October 28, 2024

To: City of Albuquerque Planning Department
Plaza del Sol Building
600 Second NW
Albuquerque, NM 87102

Re: **Self-storage**
Project #: PR-2024-010074
Application #: SI-2024-01090

Please find the following responses addressing comments received for a hearing dated August, 7 2024. In an effort to address your comments concisely and simplify your review of these development plans, we have summarized your comments and our responses below. Your comment is listed first, followed by the response in Bold.

**1 ELEVATION - SOUTH**  
SCALE: 1" = 10'-0"

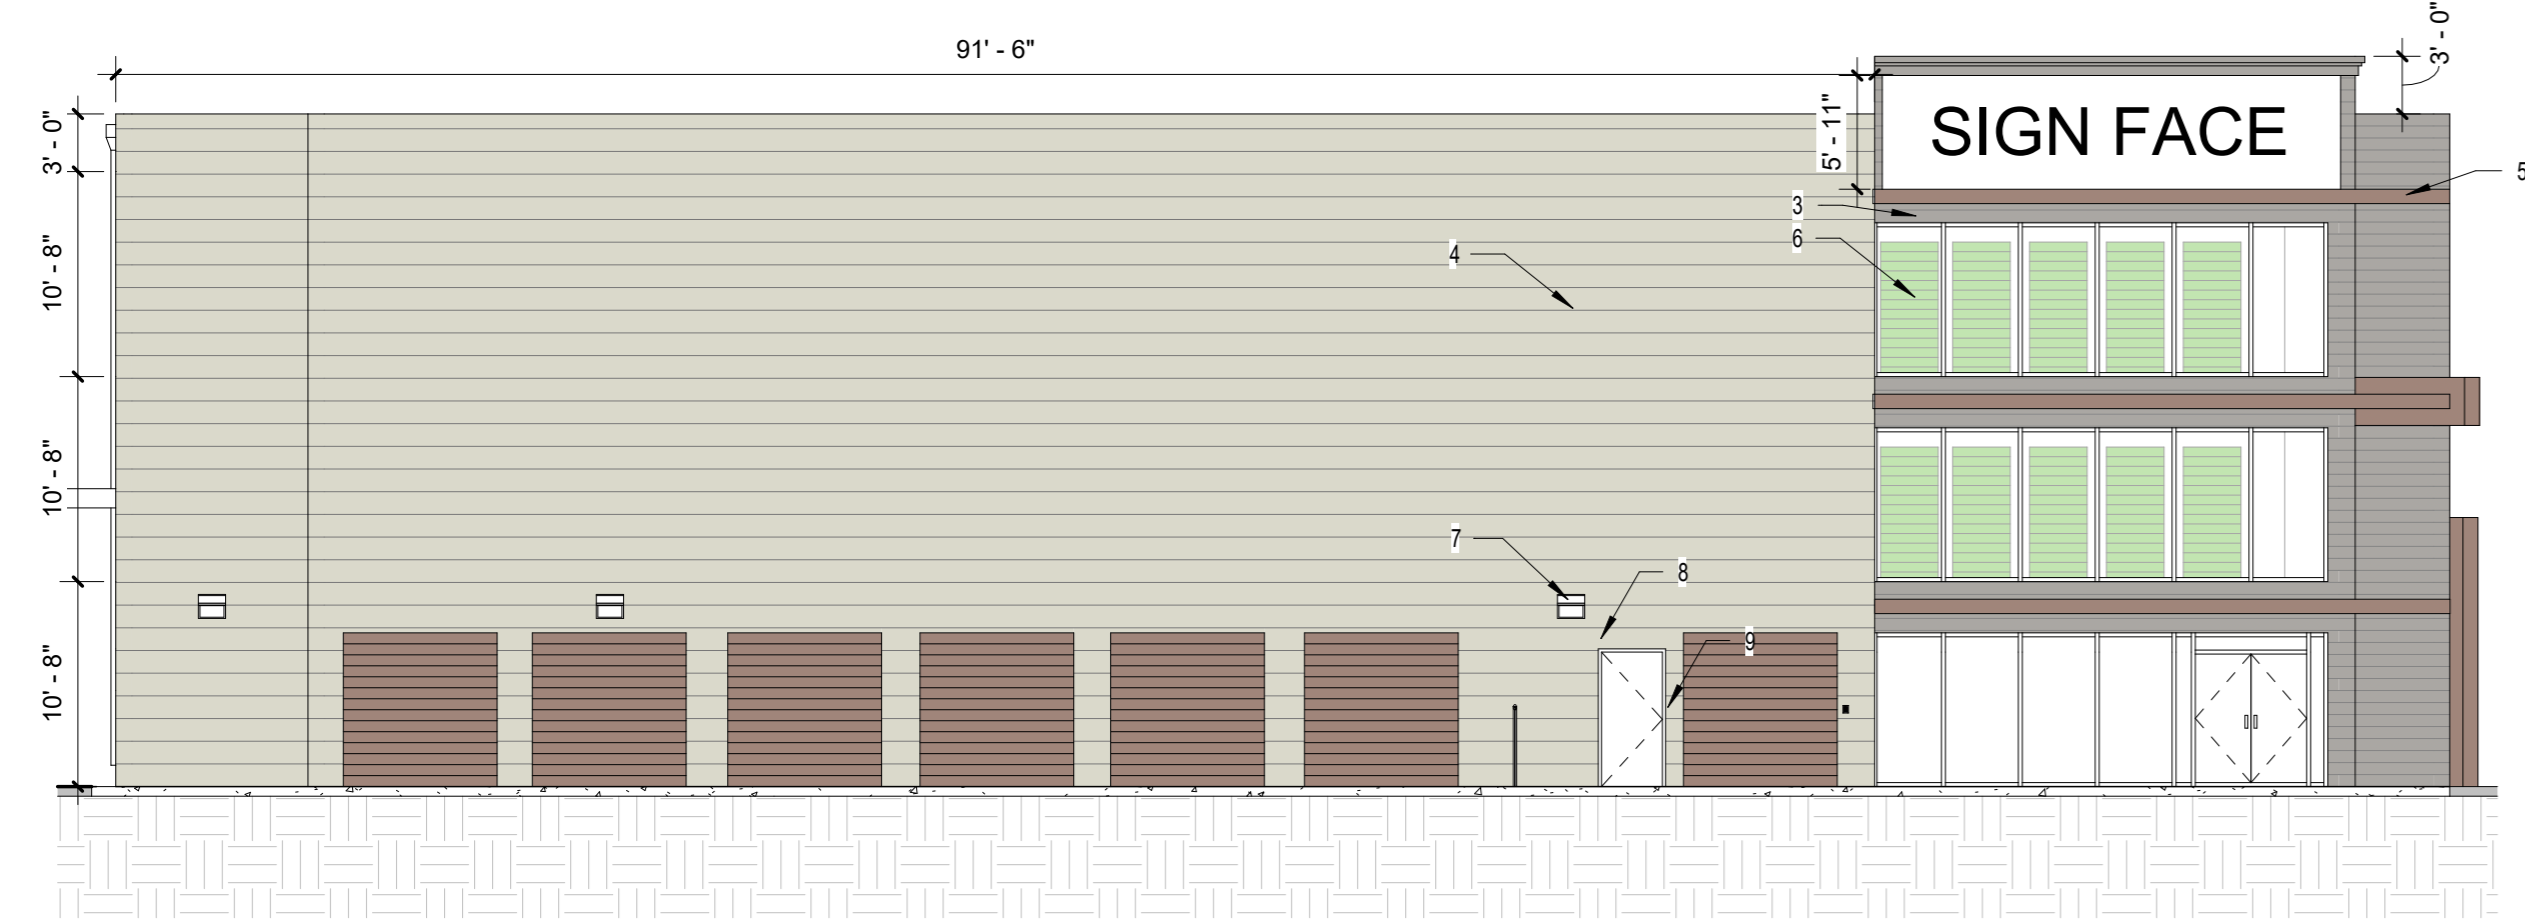
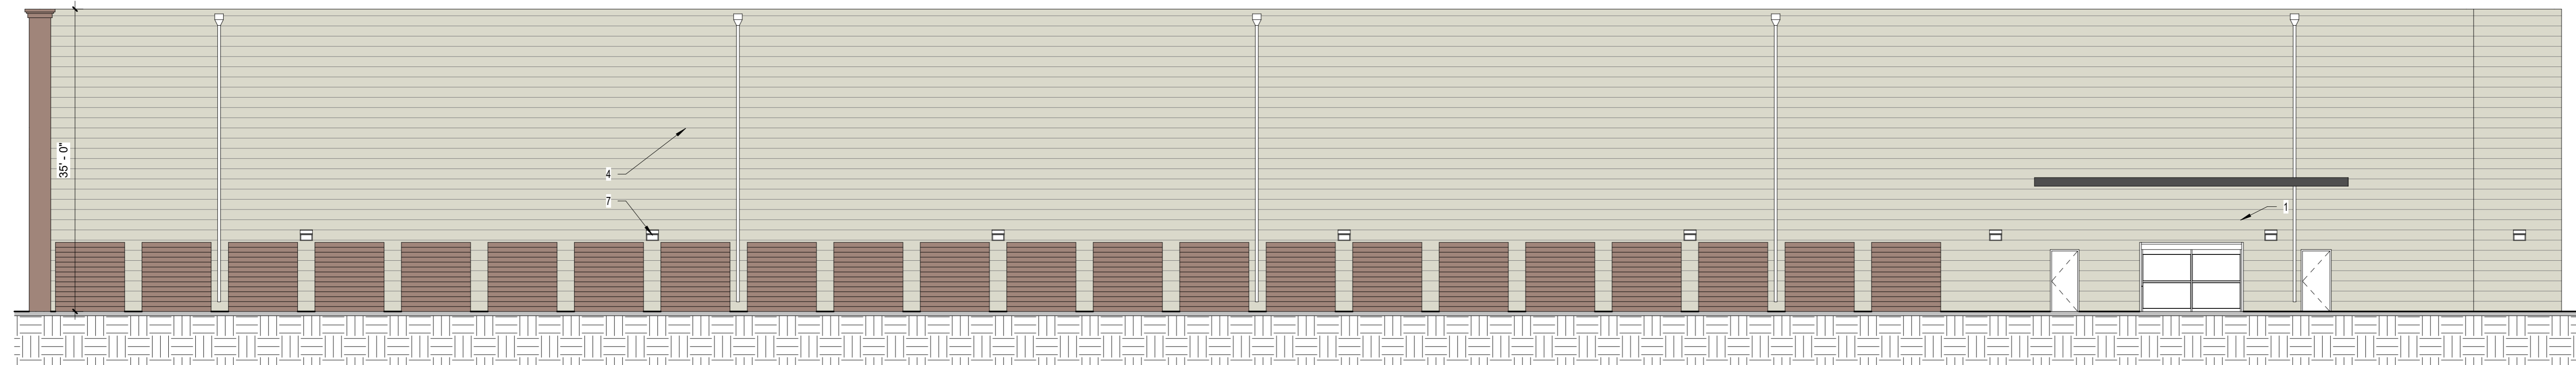
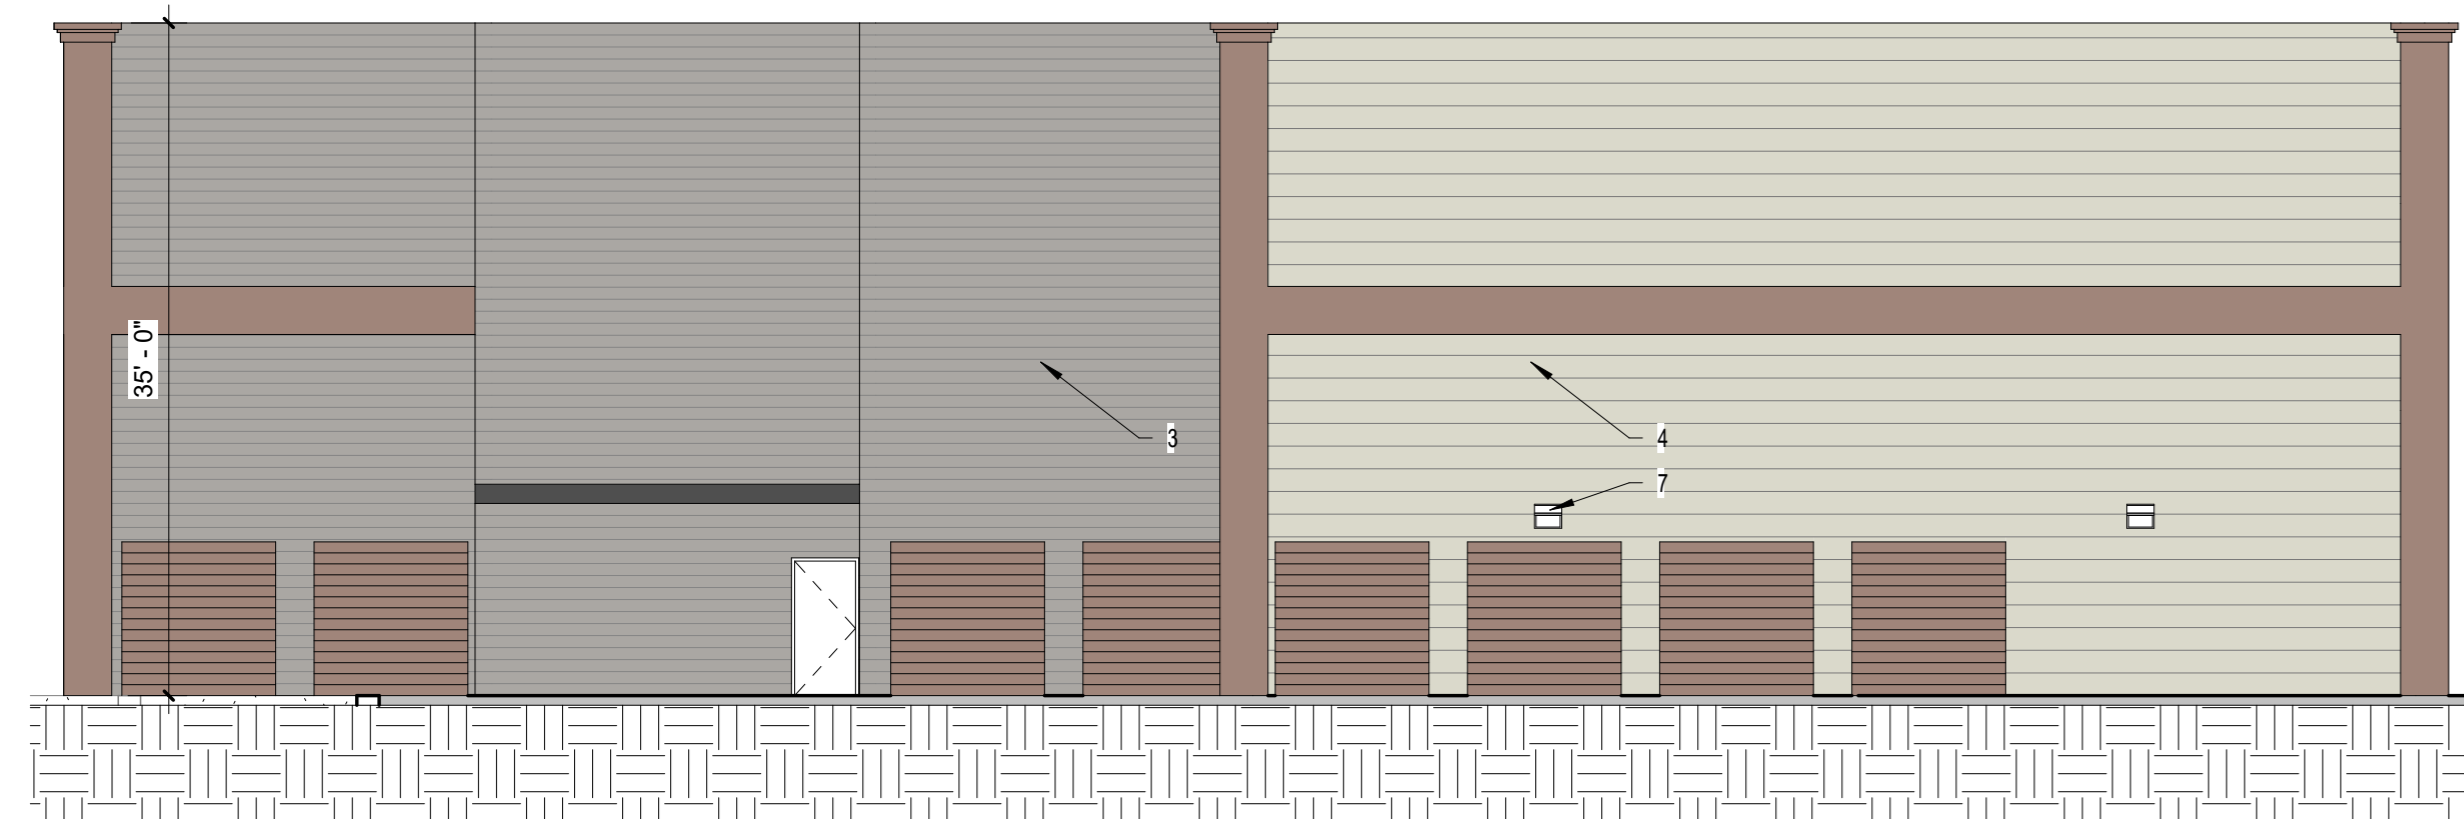
4. Elevation pages need to include details on how the project will be meeting IDO section 3-4-C-5-e. Provide additional elevation detail to demonstrate and explain compliance with all sections within 5-11-E. *Specifically 5-11-E-2 and 5-11-E-3.*
Applicant Response:
3-4-C-5-e

1. **The use of colors that contrast with the predominant color of the building is limited to 10 percent of each façade.**

Response: The color of the green that contrasts is less than 10% of each façade.

Percentages of façade that are lime green:

South – 2.7%

West – 4.7%

20. Per 5-12 for signage, NR-BP will need a signage plan or separate signage permit will be NR-C standards
Applicant Response: Signs will be permitted separate. This not has been included on the Elevation plans.

Drawing file: PR-2024-010074_SI-2024-01533_November_6_2024 (EPC SPSO) / Utility Plan.pdf

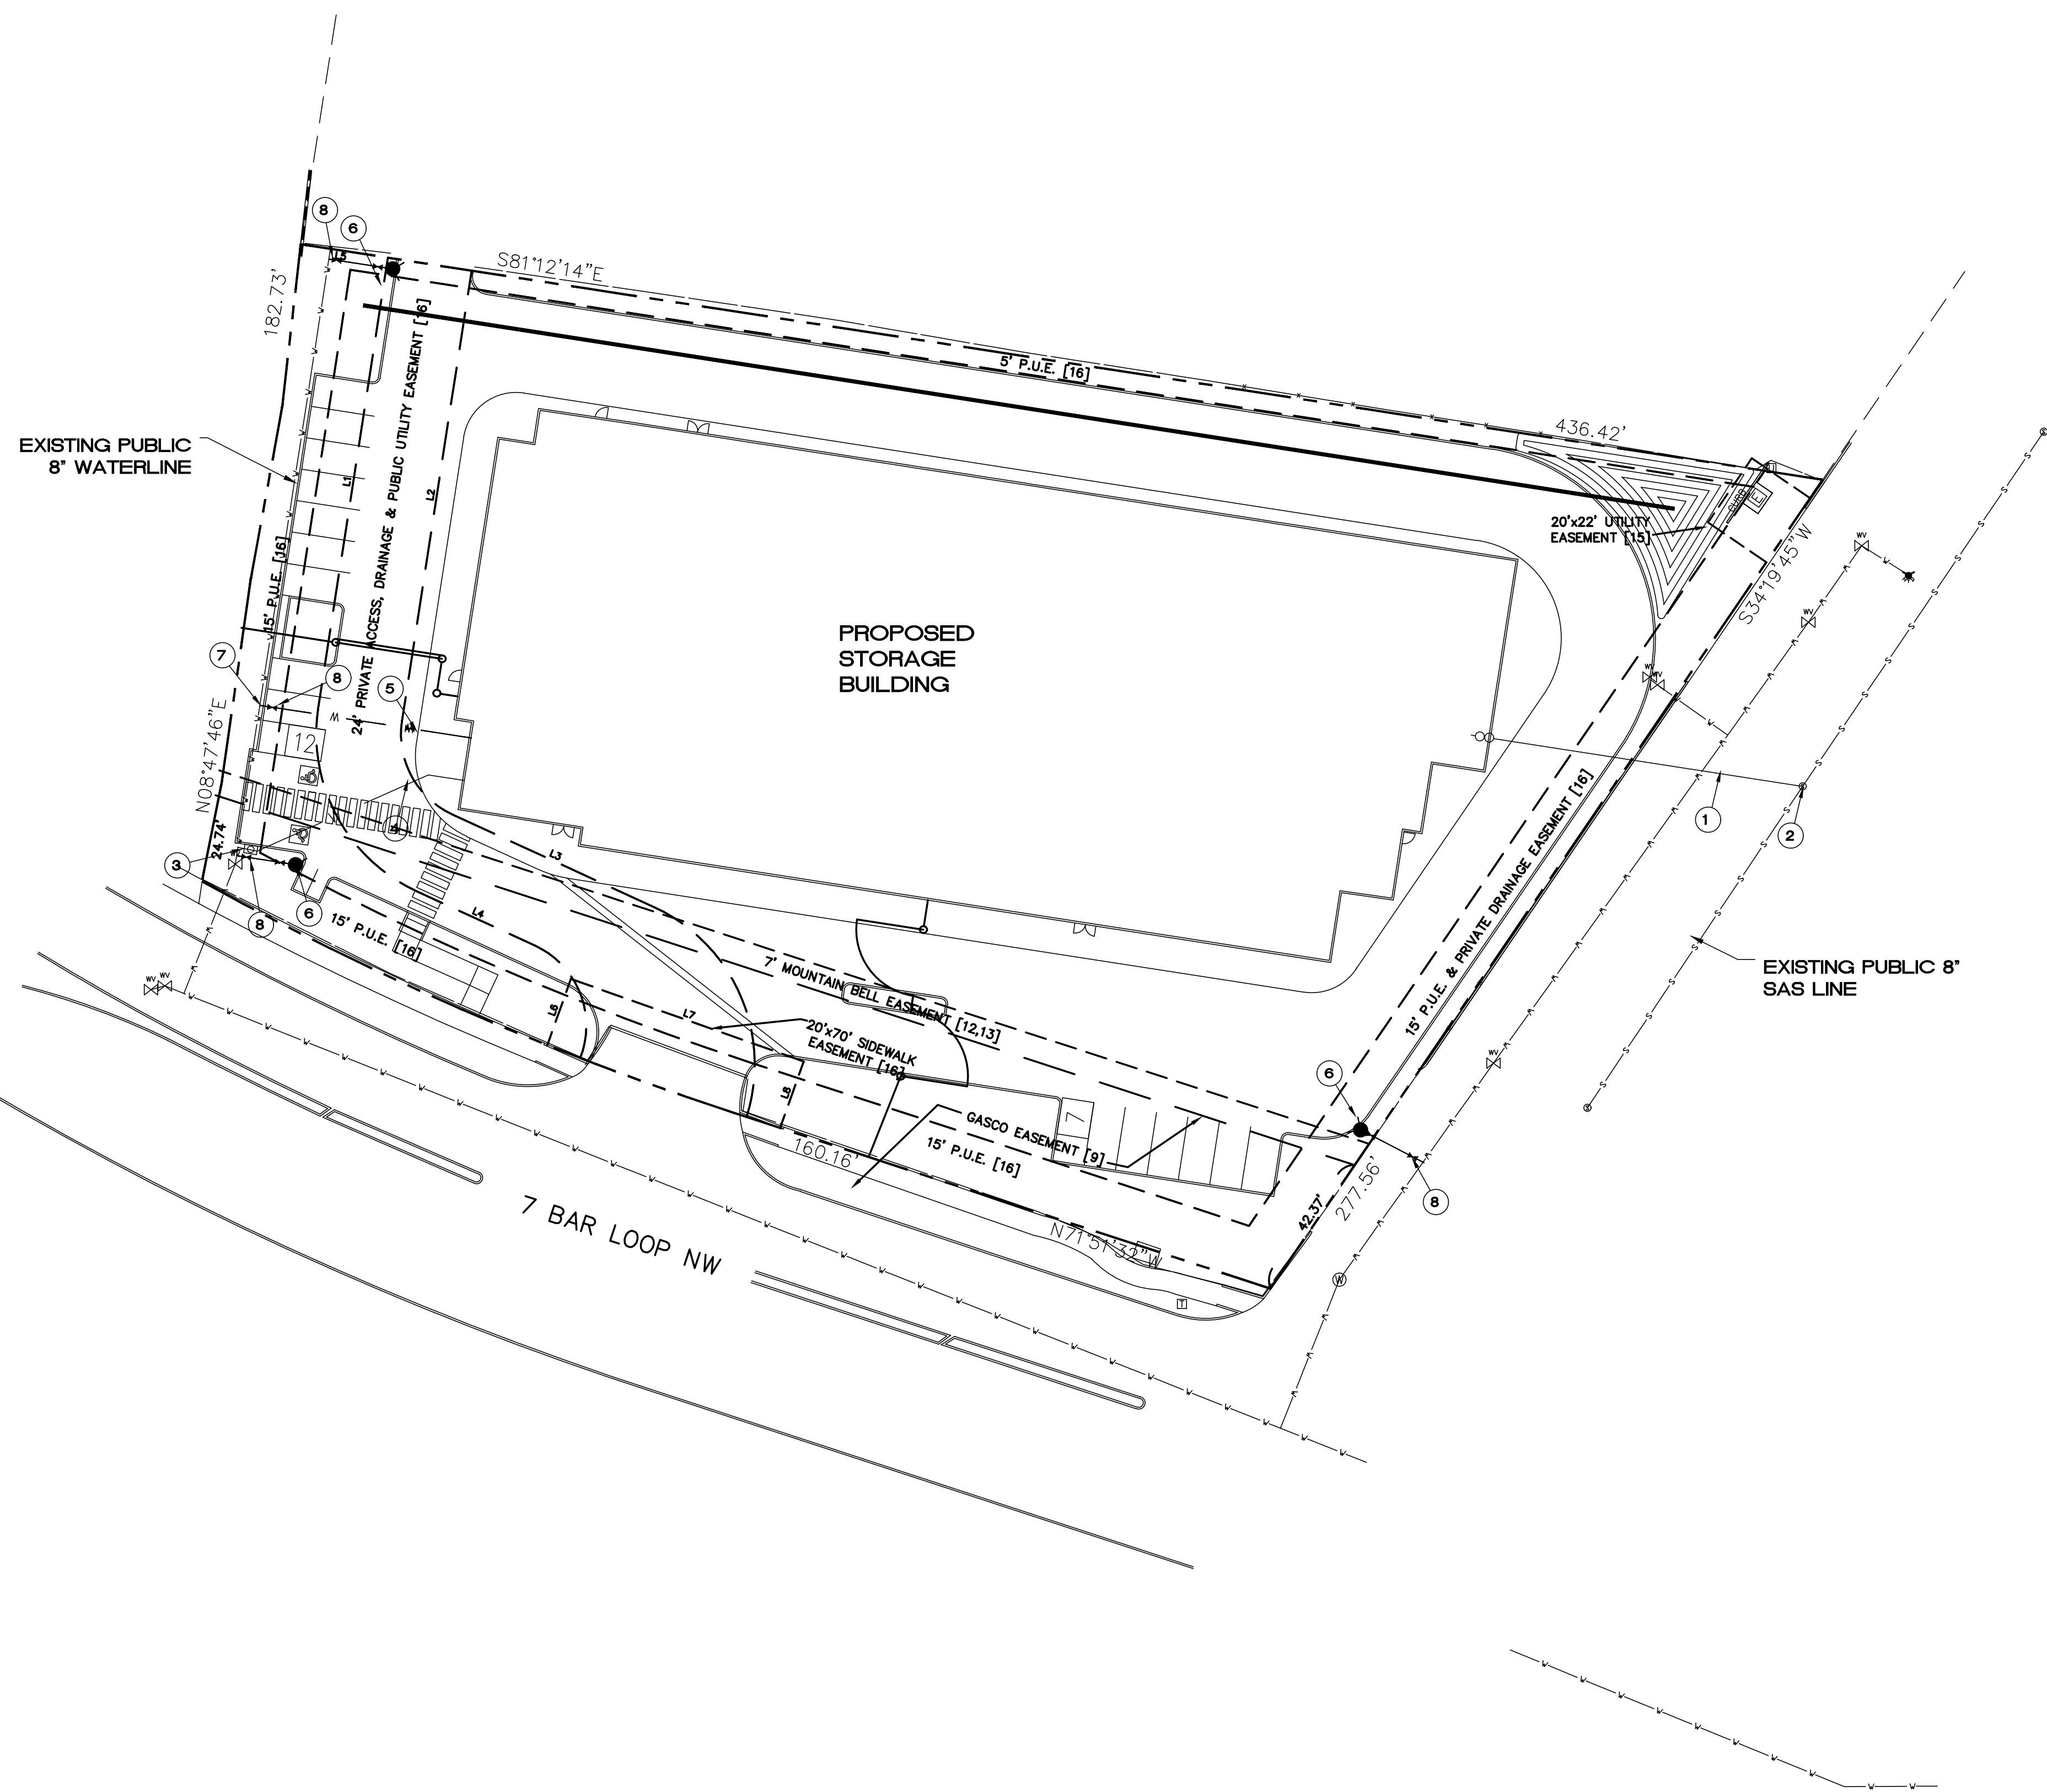
3. Please show a public valve and private valve for each proposed fire line (this includes the private fire hydrants).
Applicant Response: Refer Sheet MU-1 public valves were added to each fire line.
